Our Ref: 20/01038/HOU
Your Ref: 41 MAYLES ROAD PO4
8NP

LOCATION: 41 Mayles Road, Southsea, PO4 8NP, ,

PROPOSAL: Re-roof the existing extension including a roof-light; replace some internal walls with steel beams; and prepare a new toilet room for a macerating toilet.
(20/01038/HOU)

DRAWING TITLE  
**Existing and Proposed Section**

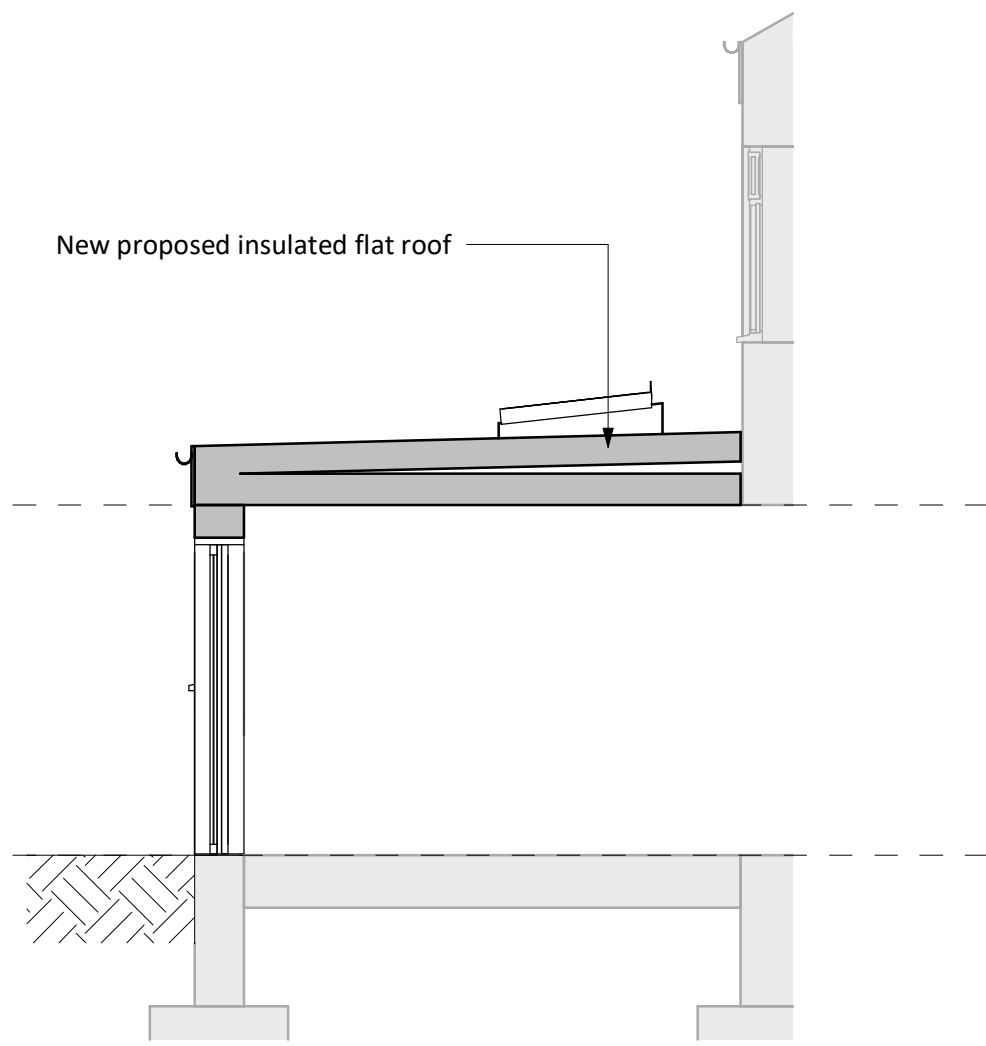
- 1) You are required to have a scale bar or dimensions on each drawing to allow the confirmation of the stated scale. Please review and amend accordingly
- 2) Please provide the side elevations showing the proposal/alterations. Please submit this at a stated standard metric scale such as 1:50 or 1:100, with a scale bar or dimensions annotated to allow the confirmation of the scale
